## **SSD-9483 Chatswood Education Precinct – Upgrades to CHS & CPS**

### **(COMMENT BY Peter Hayes, 195/809-811 Pacific Highway, Chatswood)**

SSDA - Proposed Site Plan			
scale	1 : 500@A1	drawing no.	
drawn	MR		DA-AX-A0032
checked	AC	issue	
project no	180326.00		D

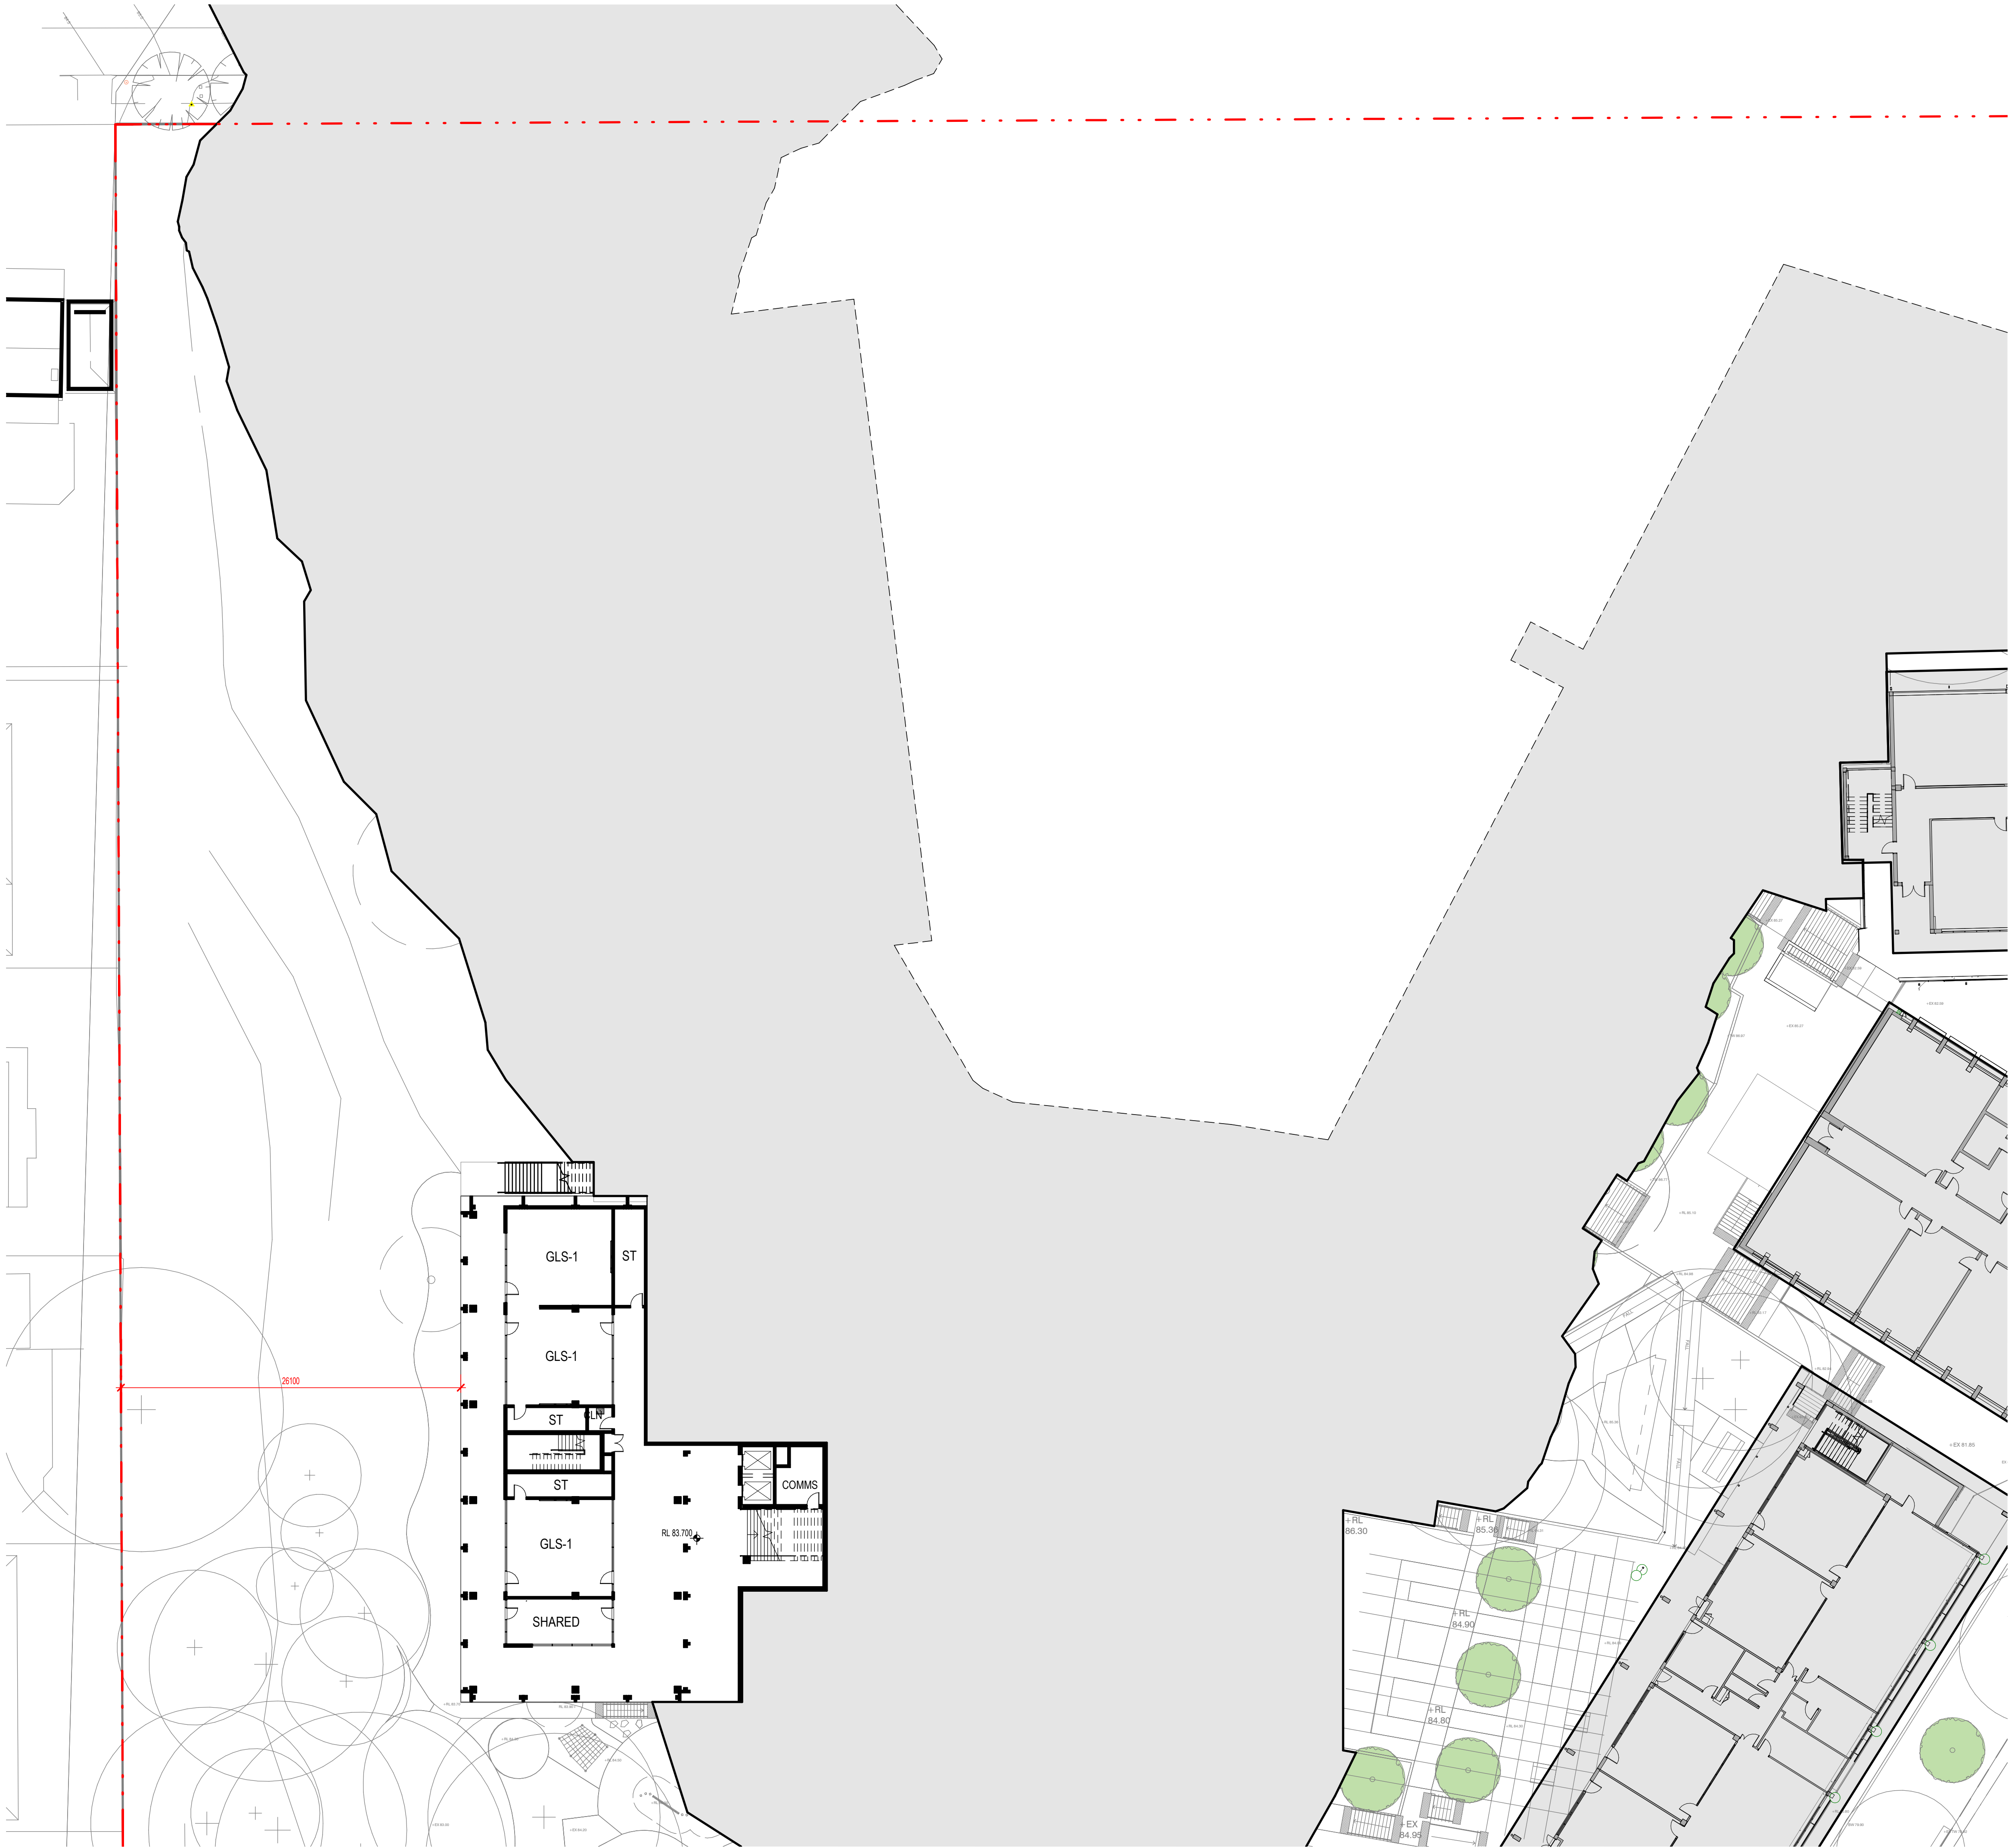
- EIS Main Report
  - Section 4.7 - Key Issues SEPP (Educational Establishments and Child Care Facilities) 2017, and
  - Section 6.1 - Built Form and Urban Design.
- Architectural Plans (Appendix 2):
  - All Area Plans GFA – Area Schedules,
  - Site Plan Proposed (Final) – neighbouring Development at 688-692 Pacific Highway, and
  - SSDA Ground Floor, Levels 1, 2, 3 and 4.
- Design Analysis Report – Parts 1-5 inclusive (Appendix 7).
- ESD SEARs Report (Appendix 28).
- Social Impact Assessment (Appendix 32).
- Preliminary Construction Management Plan (PCMP) (Appendix 33).

I should again invite attention to the opportunity presented by the land at 688-692 Pacific Highway with its associated site improvements which have been idle for the past 2 years. Being located immediately adjacent to the existing CPS Northern boundary on Pacific Highway, rezoning of this land and the acquisition of the site for CPS use would afford much needed additional area capacity.
